Our ref: [REDACTED]
Your ref: EN0110013
Date: 01 June 2026

The Drovers Solar Farm the Examining Authority's written questions and requests for information

We have reviewed the Examining Authority's (ExA) First Written Questions (dated 13 May 2026) and our comments are provided in the table appended to this letter.

DRAWING TITLE:  
ES Figure 12.16 Maximum Foundation  
Extents for Minimum Groundwater Level

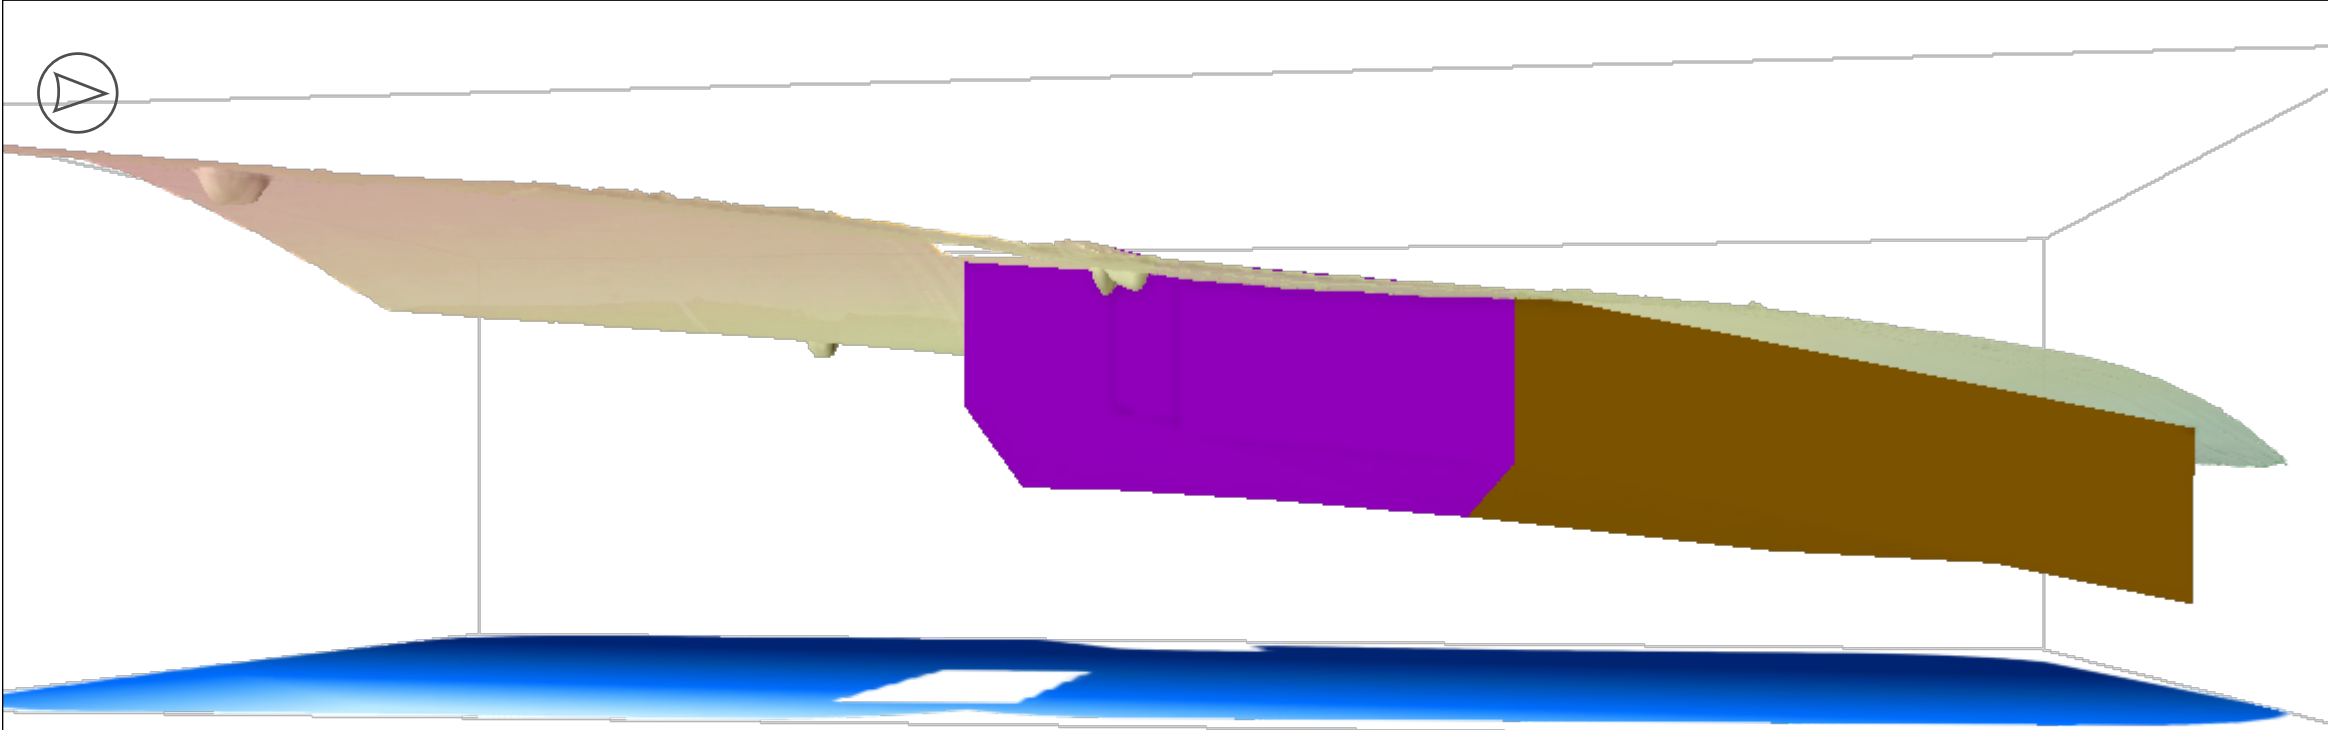
ExQ1	Question to:	Question:	
8. Flood risk, hydrology and water resources			Environment Agency Comment
Q8.0.3	Environment Agency (EA)	<p>Water Framework Directive assessment for groundwater bodies</p> <p>In reference to paragraphs 5.16.2 and 5.16.14 of NPS EN-1, could the EA confirm whether it agrees with the conclusions of the WFD assessment [APP-171]? In particular, the ExA seeks confirmation as to whether comments made in the EA's RR [AS-062] regards the adequacy of the applicant's characterisation of groundwater levels and flow direction within Chapter 12 of the ES would have implications for the findings of the WFD assessment for groundwater bodies.</p>	<p>At Relevant Representations stage [AS-062] we submitted several comments regarding concerns about the adequacy of the Applicant's hydrogeological model (refs. EA04, EA18, EA19, EA20, EA22 and EA23).</p> <p>Following Issue Specific Hearing 1, in correspondence with the Applicant, we have requested the Applicant produces a technical note summarising their review of groundwater model data provided by the Environment Agency and any implications for their hydrogeological model for the Proposed Development. The Applicant proposed to update Chapter 12: Water Resources at Deadline 2 to compare the North East Anglia Chalk model results (wet day) with the groundwater elevations derived for the triangulation analysis used in the Environmental Statement. We find this approach acceptable, and look forward to reviewing the updated document.</p> <p>Provided that adequate post-consent ground investigation and monitoring are secured via the Development Consent Order, if groundwater levels are found to interact with the proposed BESS and/or Substation foundation extents, and based on the proposed mitigation measures set out in APP-171 Table 12-4 and secured via the outline Construction Environment Management Plan (CEMP), we concur that any significant risks posed to the WFD Groundwater body by these construction activities can be adequately mitigated.</p> <p>The Applicant also indicates in APP-171 Table 12-4 that impacts from Horizontal Directional Drilling (HDD), if required, can be mitigated in part by carrying out these works when groundwater levels are not within 15m of ground level. We seek assurance from the Applicant that should post-consent monitoring demonstrate that interaction of HDD with groundwater is unavoidable, potentially significant effects on the WFD Groundwater body can be mitigated with an alternative approach.</p>

Q8.0.4	Environment Agency (EA)	<p>Flood Risk Assessment (FRA)</p> <p>The ExA notes that BDC's RR [RR-011] defers to NCC and EA on matters of water resources and flood risk.</p> <p>Regarding the updated ES Appendix 12.2: Flood Risk Assessment [AS-053], does the EA agree with the conclusions in Section 12.6 and the rationale for the section on the sequential test, application of the sequential approach and the exception test (paragraphs 12.2.44 to 12.2.55)?</p>	<p>The application and adequacy of the Sequential Test sits under the remit of the Local Planning Authority. However, we note that the site lies almost entirely within Flood Zone 1, and development will be at low risk of flooding from rivers and sea. There is a small section of the site under work no.11 – to be used for Skylark plots - which falls within flood zones 2 and 3. It is also acknowledged that flood risk has been considered in the site selection process. Given these details, we consider the conclusions on the Sequential and Exception Tests within the submitted FRA to be acceptable.</p> <p>We have made separate comments relating to flood mitigation at the BESS within the site (EA12), where infrastructure is proposed to be raised in mitigation of potential surface water flood risk impacts. The applicant has made commitments within their first draft of the Statement of Common Ground to</p>

ExQ1	Question to:	Question:
		ensure that surface water flooding will be managed appropriately to avoid and manage risk to the BESS areas.
